Subject: RE: Planning Consultation on: Y/33/20/PL

Engineers Comments Regarding Surface Water Drainage

Registered: 25th March
2020
Site Address: Sunnymead North End Road Yapton BN18 0DL
Grid Reference: 498169 104354

Description of Works: Demolition of existing dwelling & outbuildings & erection of 7 No. dwellings comprising 3 No. 4 bed houses, 1 No. 3 bed house & 3 No 2 bed houses. This application is a Departure from the Development Plan.

Drawing name:
Proposed 4B7P House Side Elevations

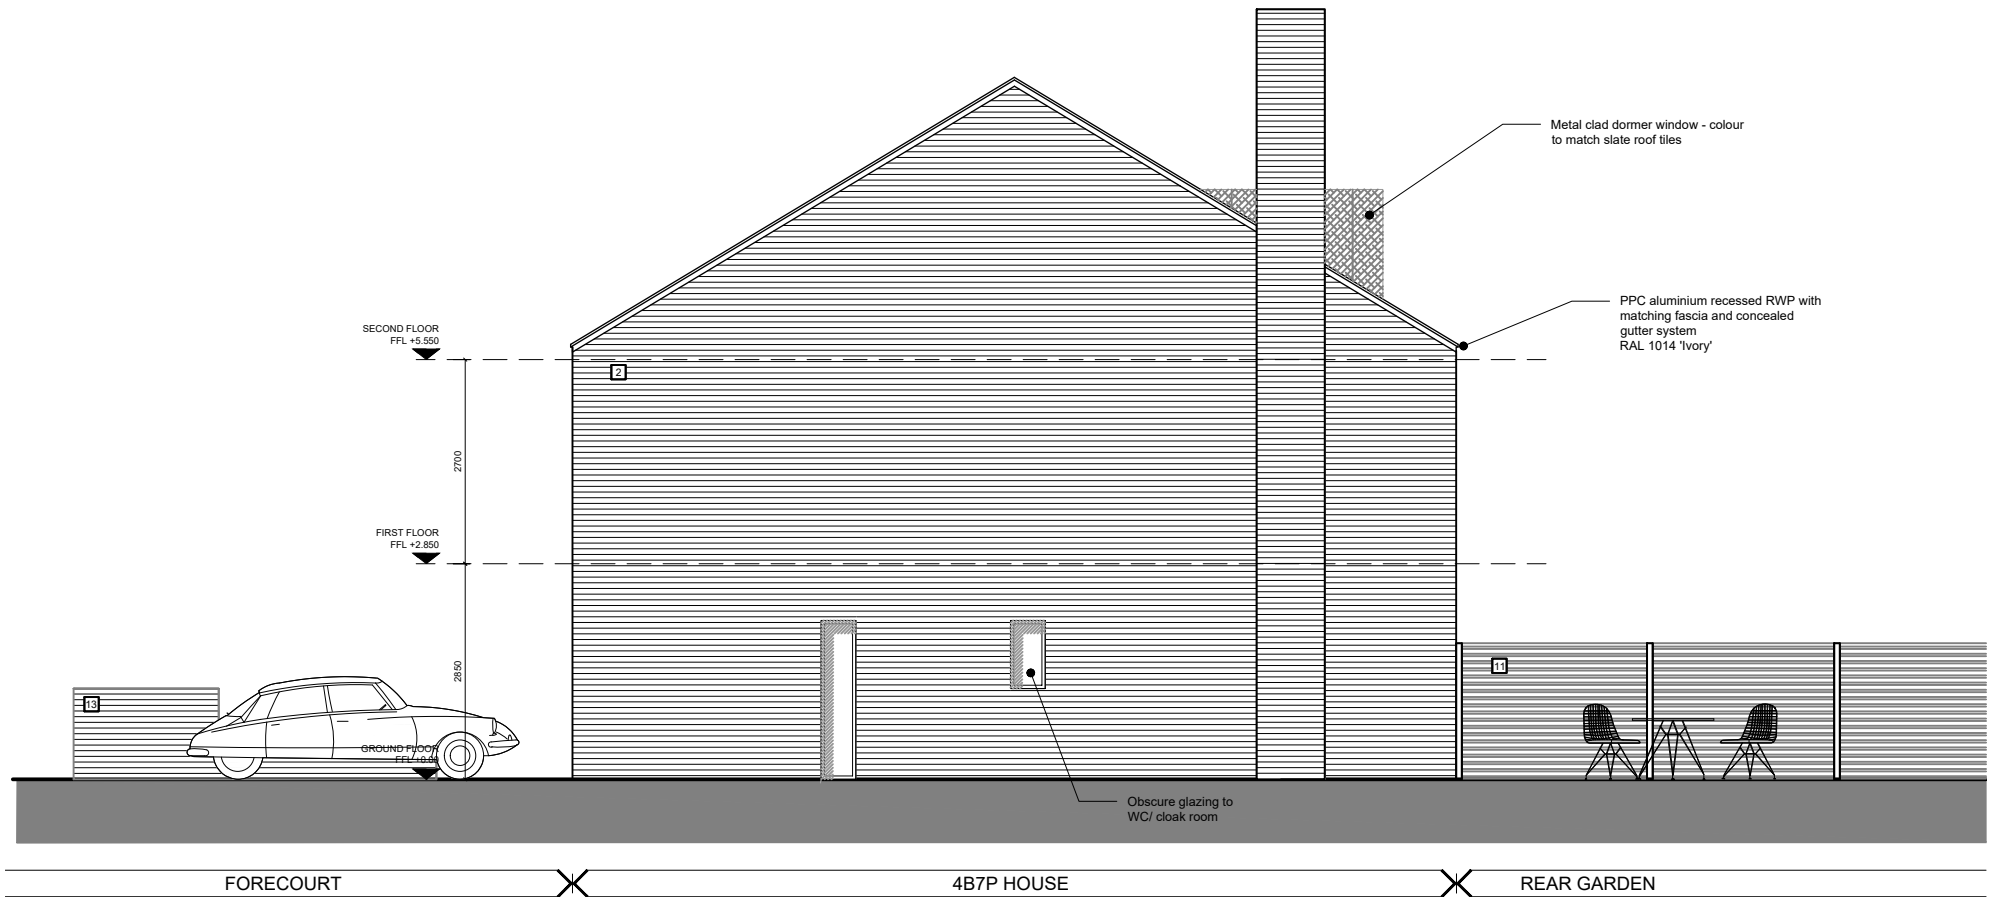
- b. If the intention is to raise the ground levels (which appears to be the case from the elevations of the buildings and the street elevation sheet), then the ground level may be being raised by up to 1.85m. This could remove a large area of flood storage, however the properties would be less likely to be flooded themselves but could increase flood risk elsewhere.

Soakage Test Report

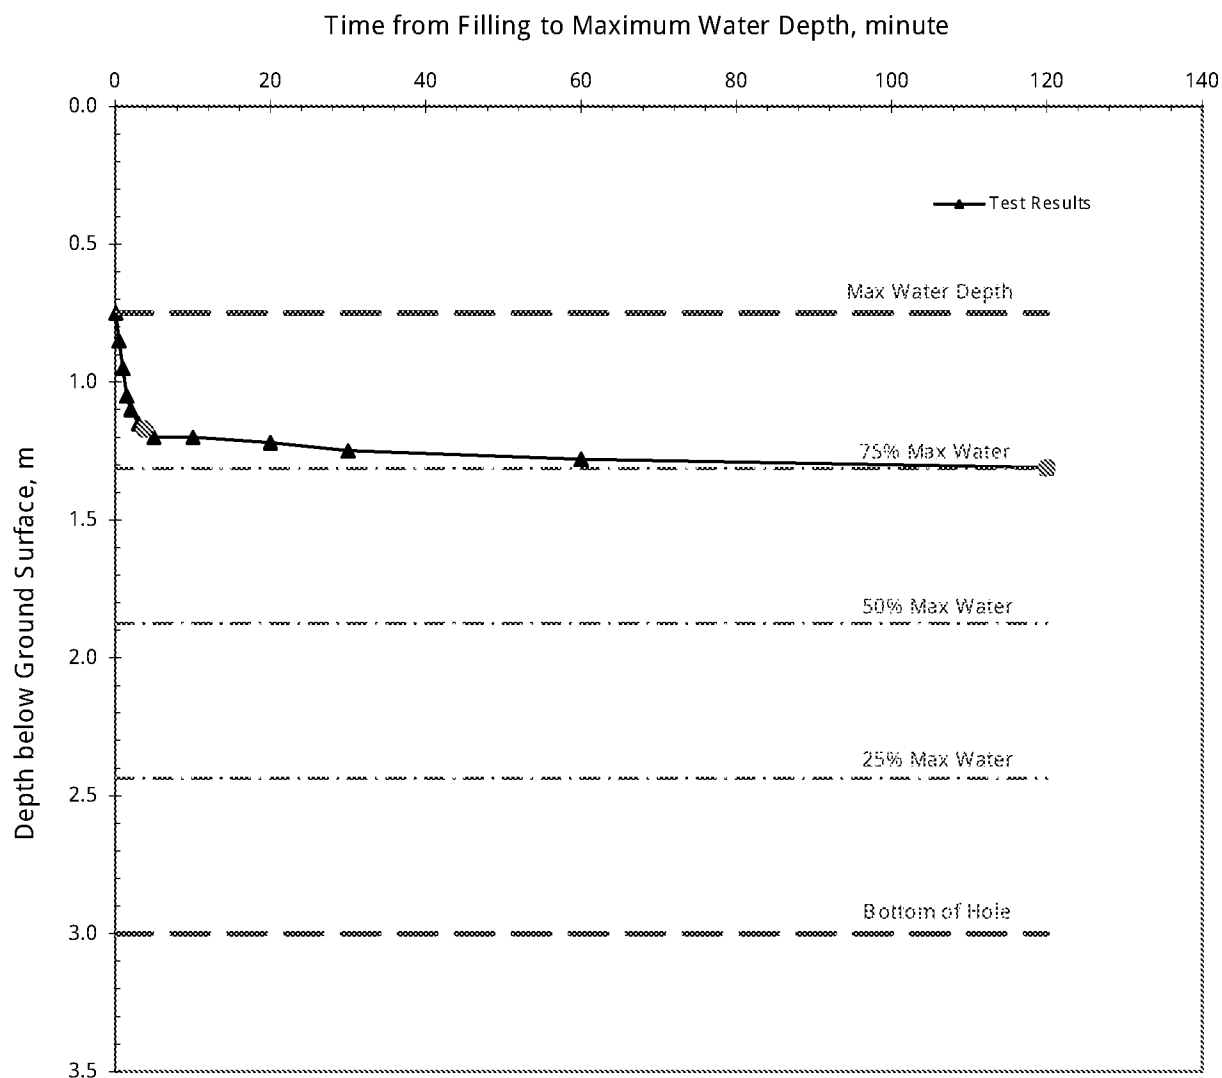
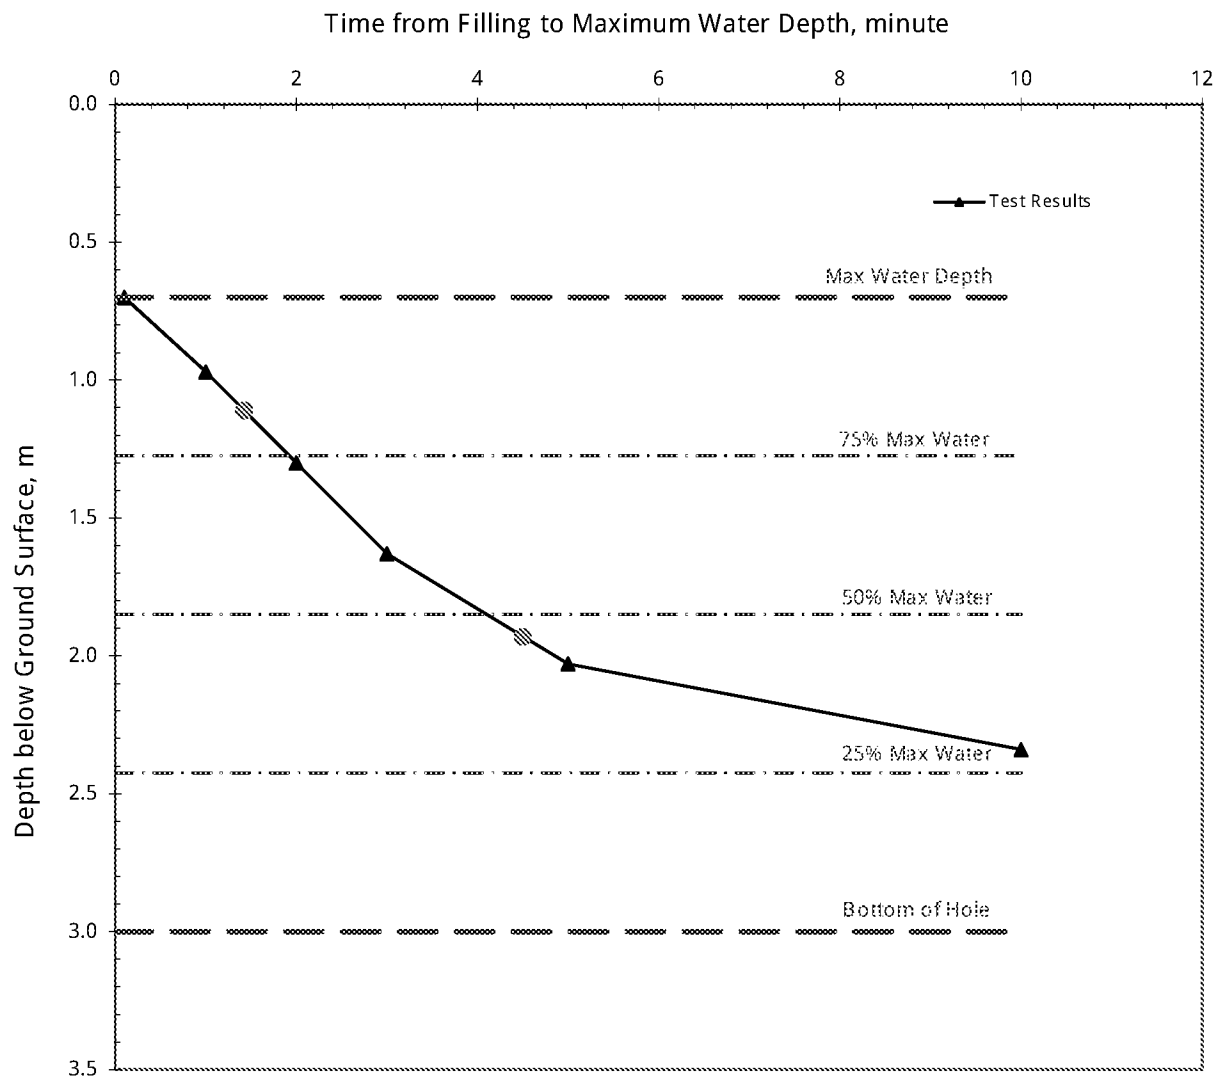
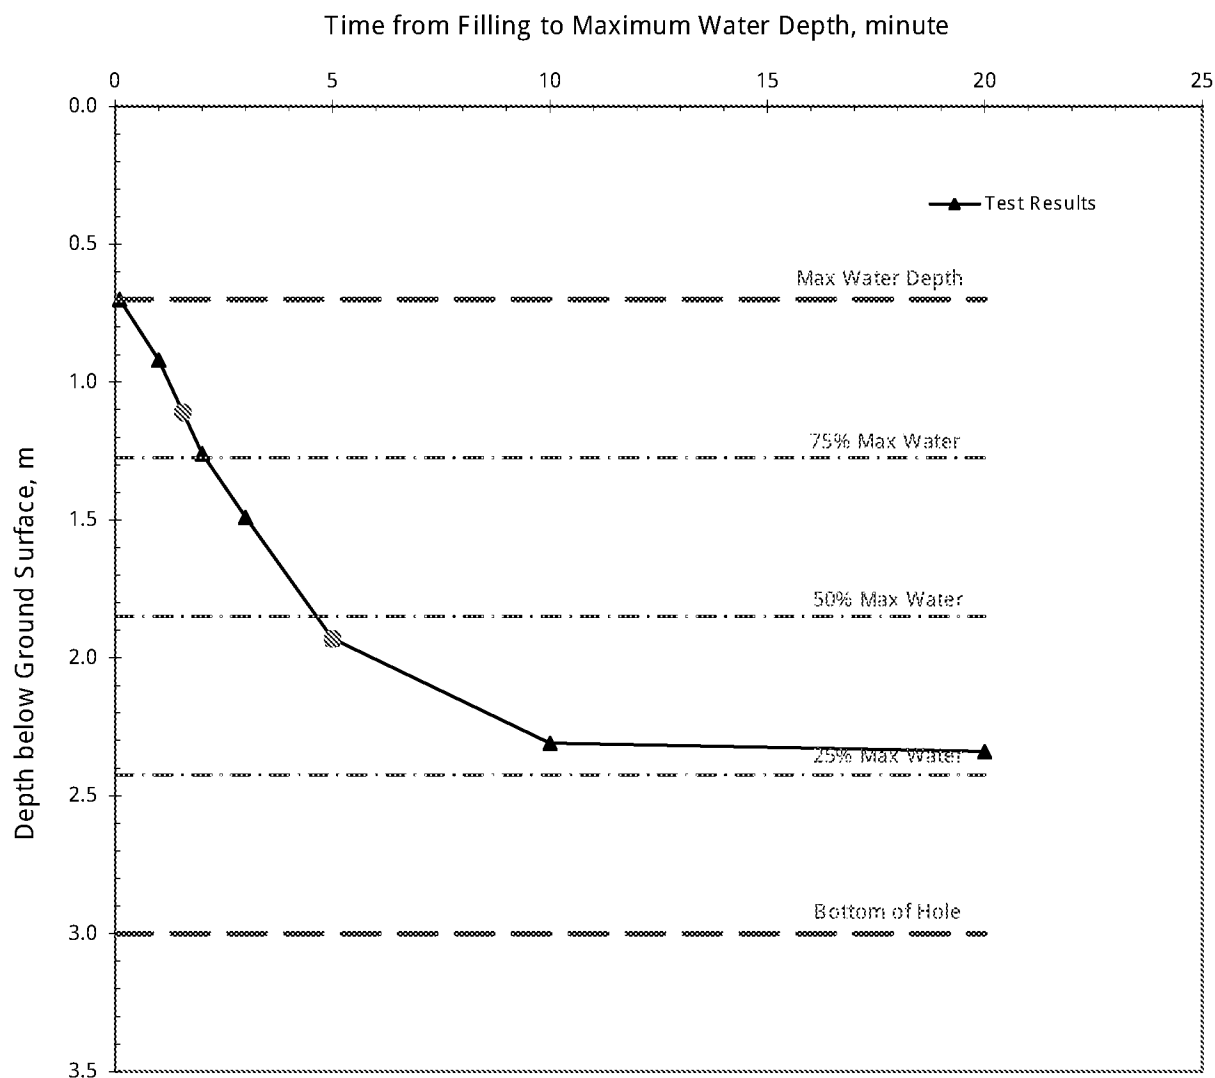
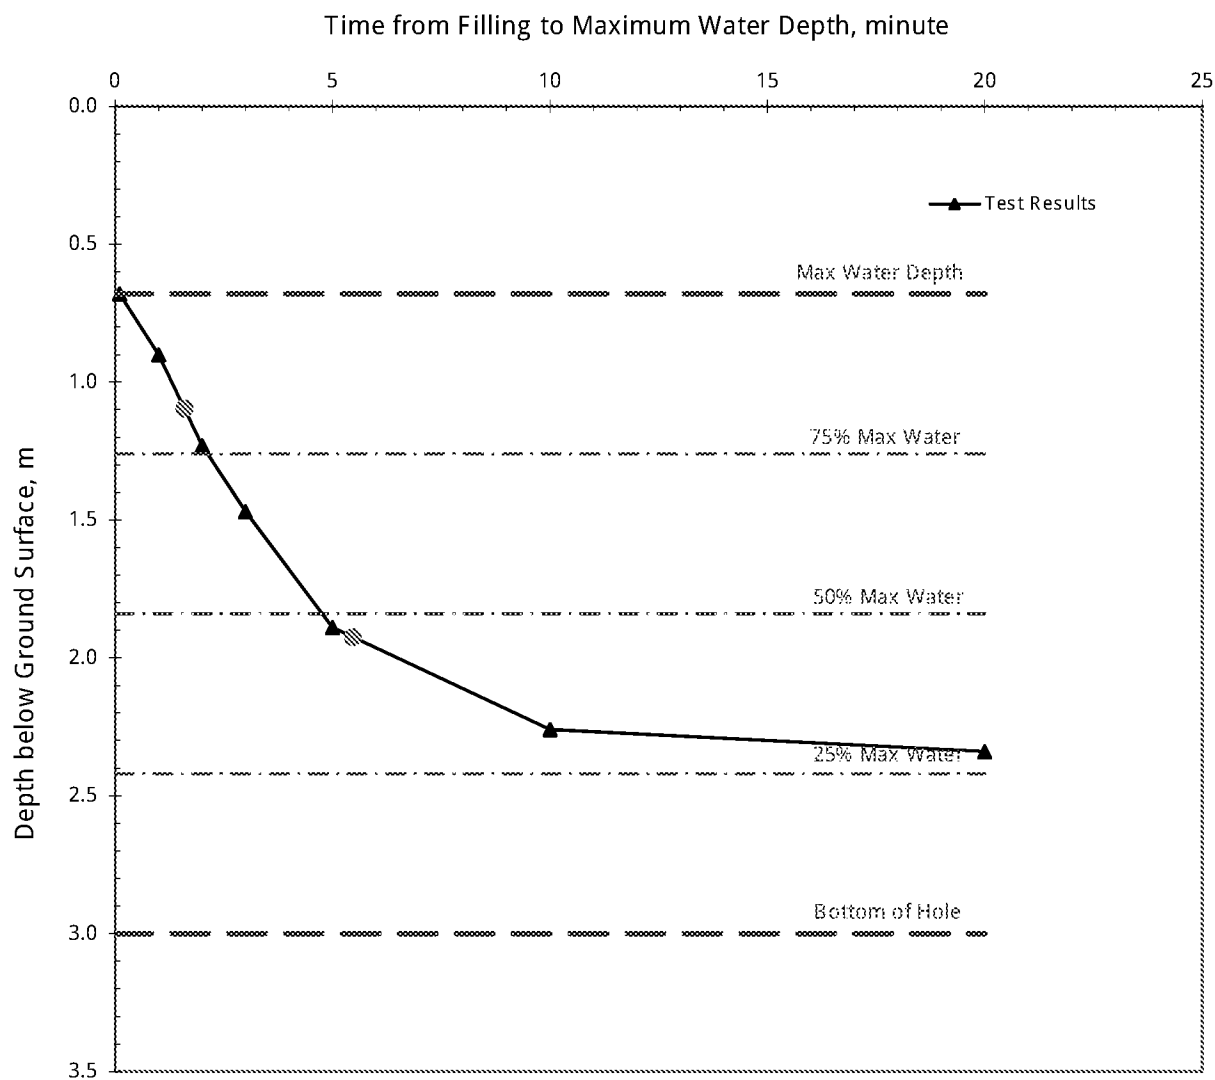
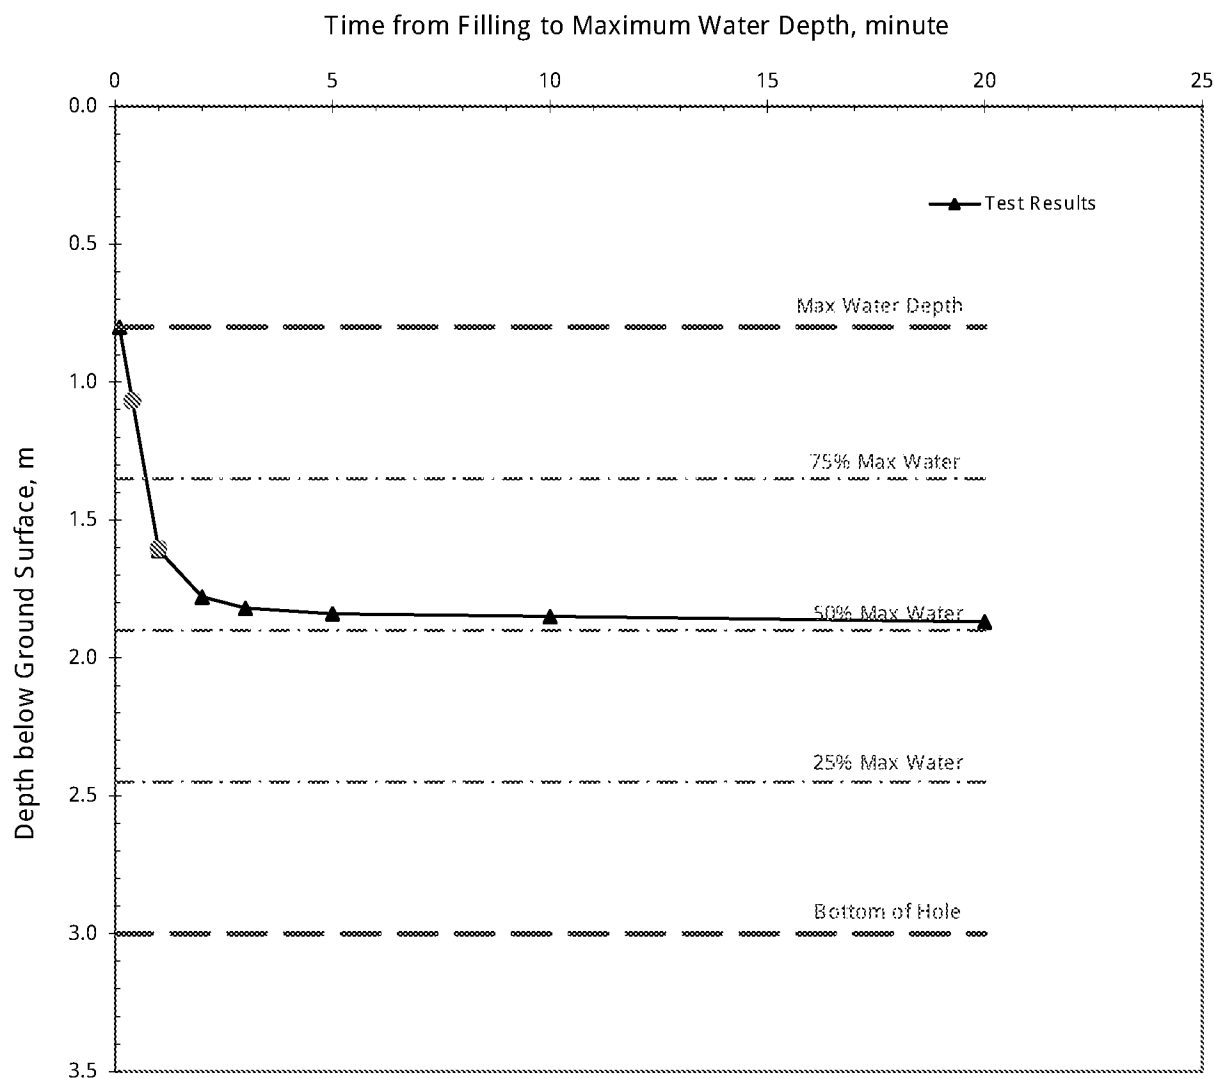
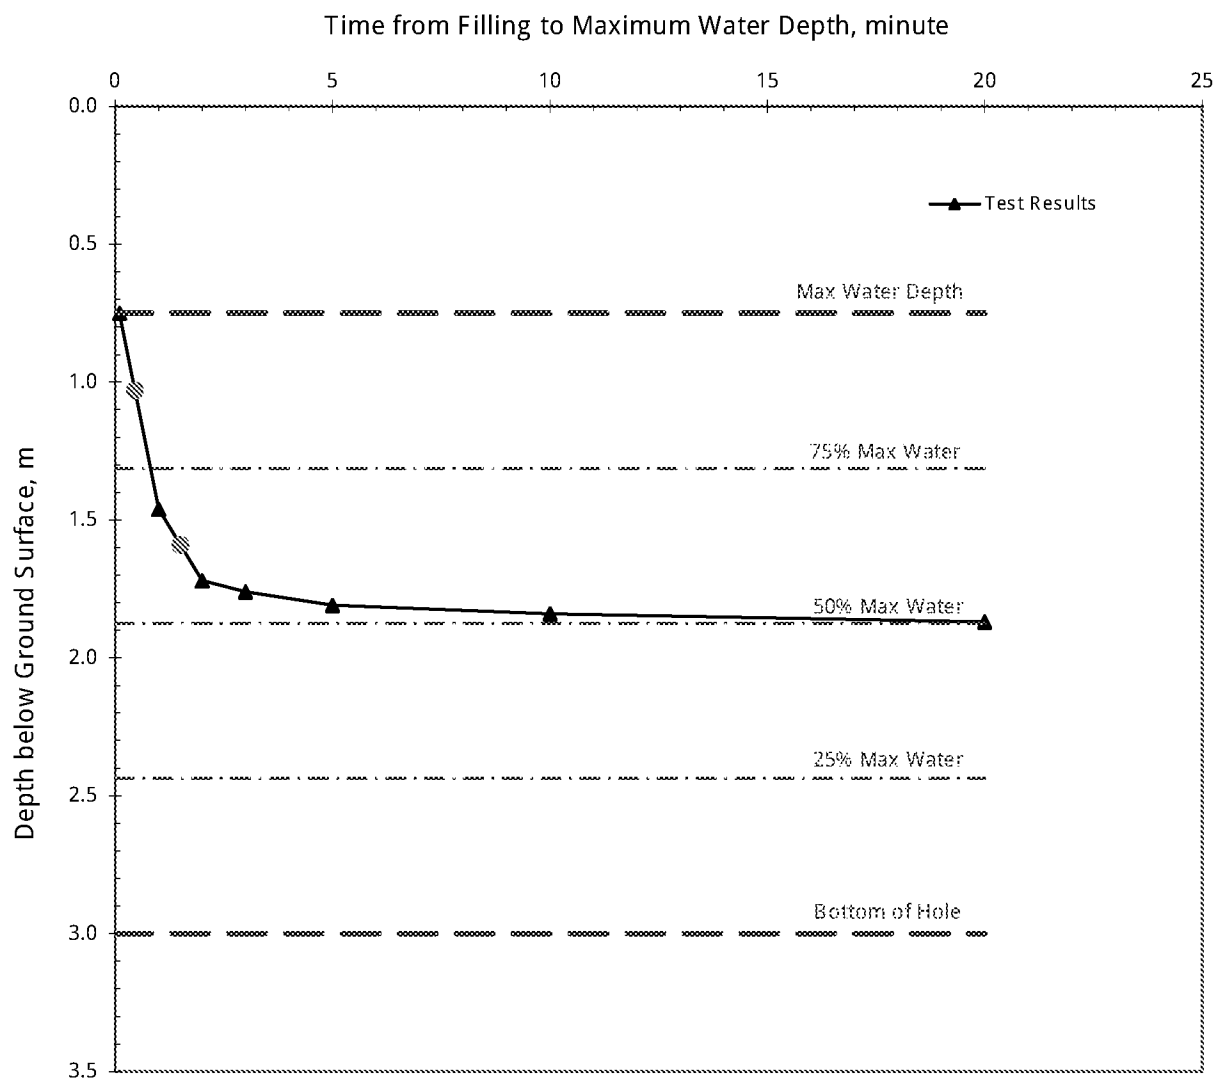
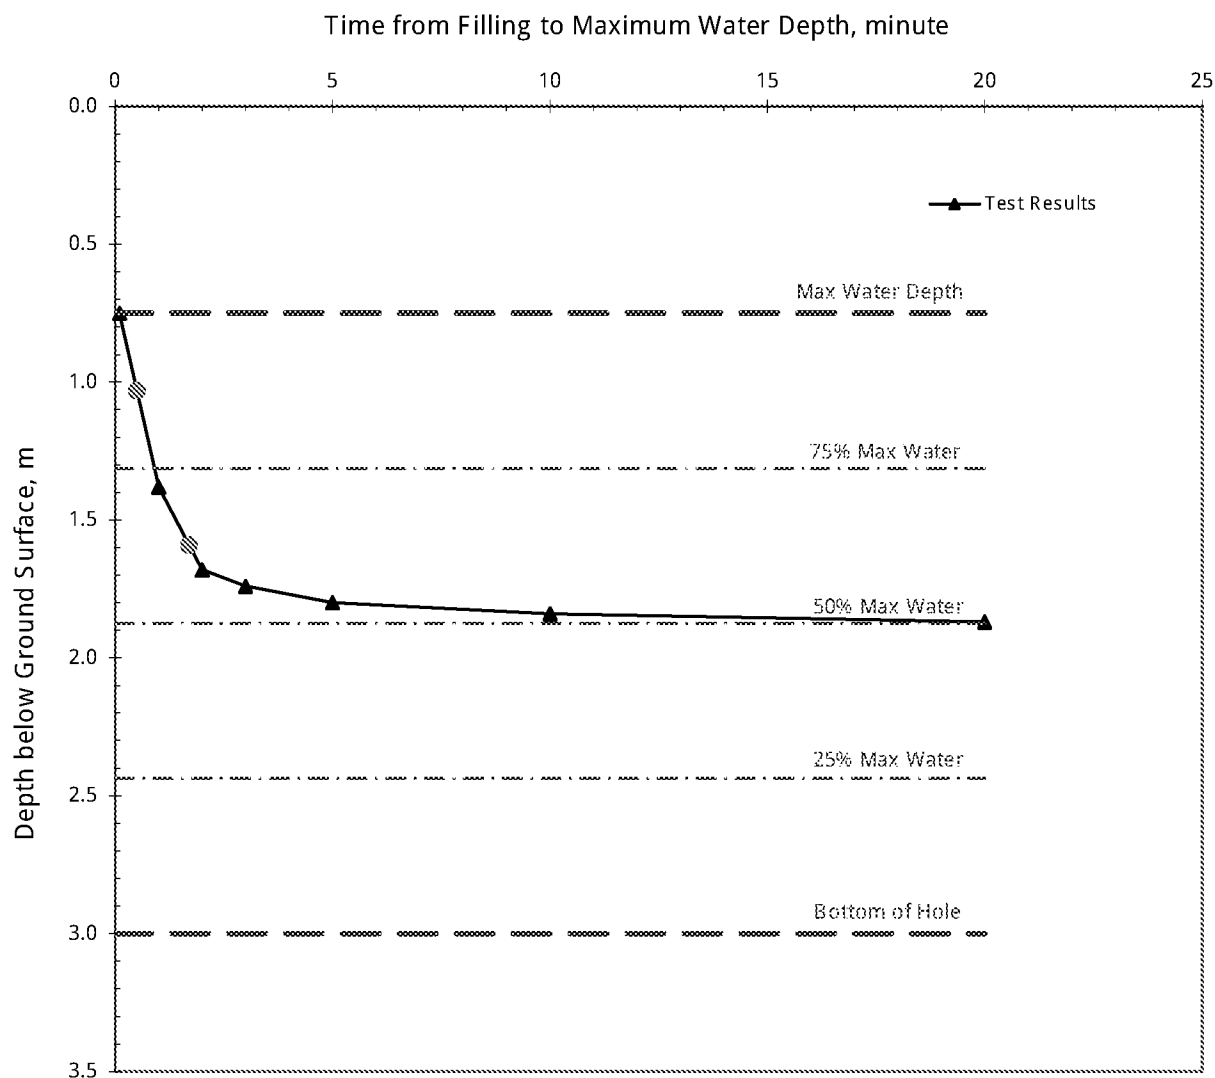
2. Infiltration testing was completed in October and not in accordance with BRE365. The applicant will need to carry out winter infiltration tests in strict accordance with BRE365, in the locations and at the depths of any proposed infiltration structures. It is expected that this will include both shallow and deeper tests to account for the permeable paving and the proposed soakaways. The testing should be undertaken in the months of January/February when the ground is most saturated and above the recorded highest groundwater level (see point 3).
